From: Laura Gibbons <Laura.Gibbons@arun.gov.uk>
Sent: 24 November 2020 11:46
To: Planning.Responses <Planning.Responses@arun.gov.uk>
Cc: Anita Gardner <Anita.Gardner@arun.gov.uk>
Subject: FG/123/20/PL- Land at former McIntyre Nursery Littlehampton Road Ferring BN12 6PG

Engineers Comments Regarding Surface Water Drainage

TITLE
PROPOSED SITE & BLOCK PLAN

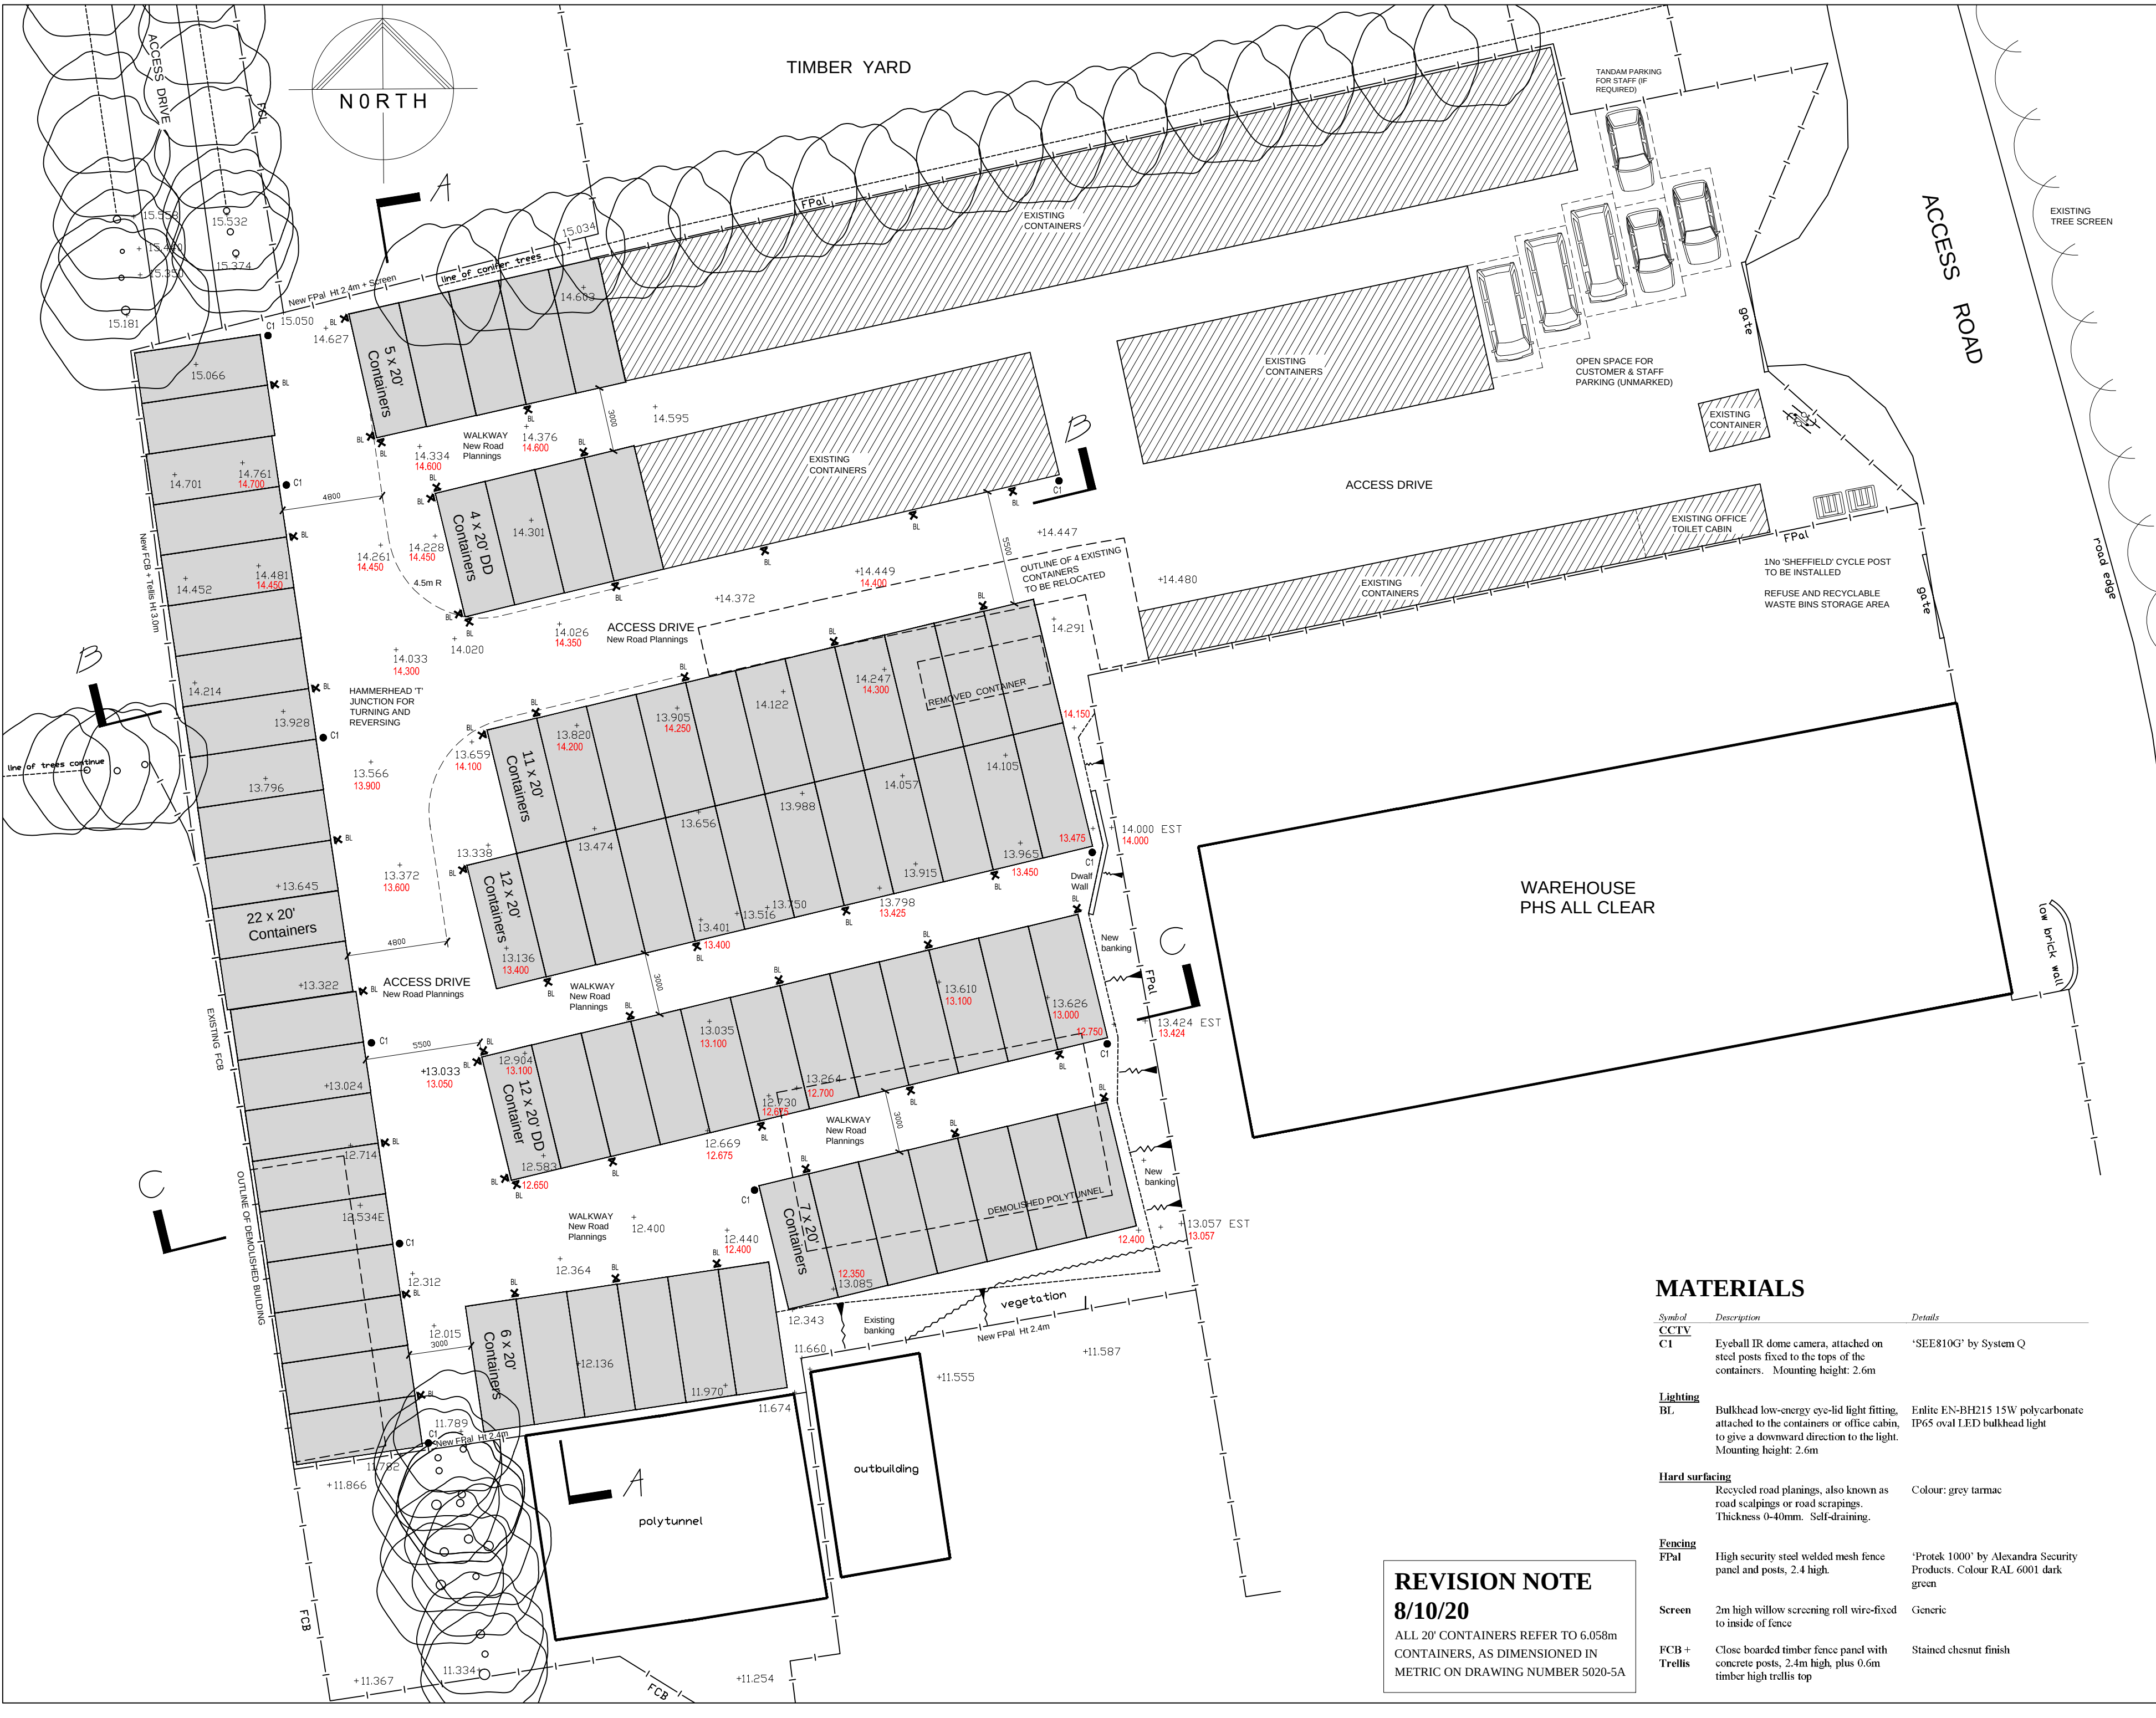
The application includes a change of surfacing to a significant area. Please can the applicant supply a cross section of this proposed surfacing along with materials specification demonstrating its permeable nature prior to determination. Surfacing material must have reduced fines and a suitable void ratio.

"Development shall not commence, other than works of site survey and investigation, until full details of the proposed surfacing have been submitted to and approved in writing by the Local Planning Authority. The design must demonstrate a fully permeable surface, including any proposed sub-base."
